Please ask for: Ms Iqraa Malik
Email: iqraa.malik@terraquest.co.uk
Telephone: 01212341390
Our Ref: M/113/21/HH
Your Ref:
Date: 13th August 2021

Application for Planning Permission for Works or Extension to a Dwelling

Development: Single storey rear extension with balcony above and alterations to fenestration
Location: 17 Sea Way Middleton-On-Sea PO22 7RZ

PROPOSED EAST ELEVATION

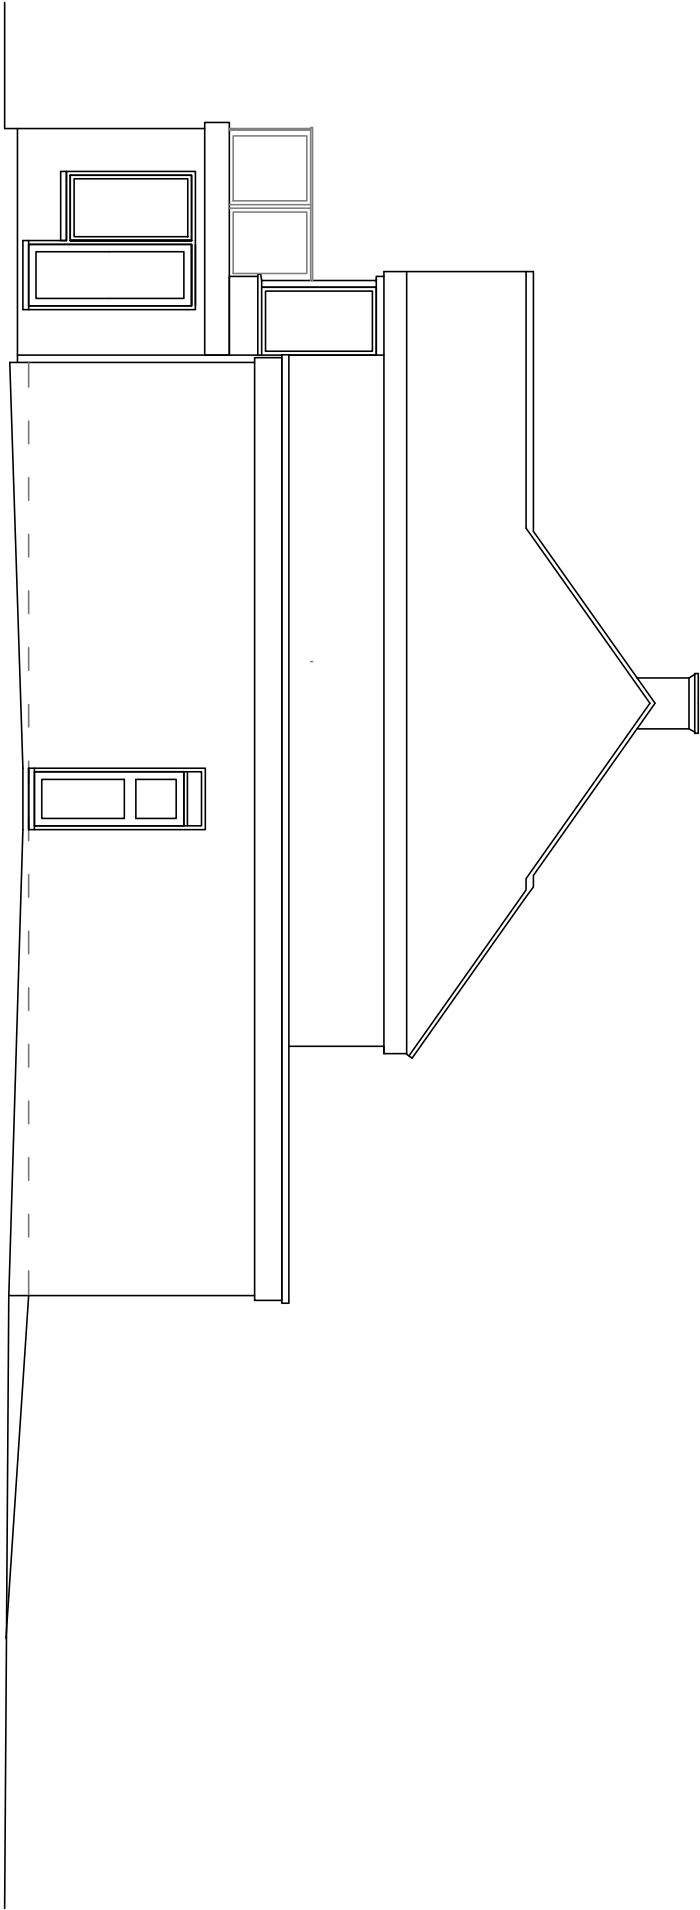
The door on the proposed east elevation is missing from the proposed ground floor plan
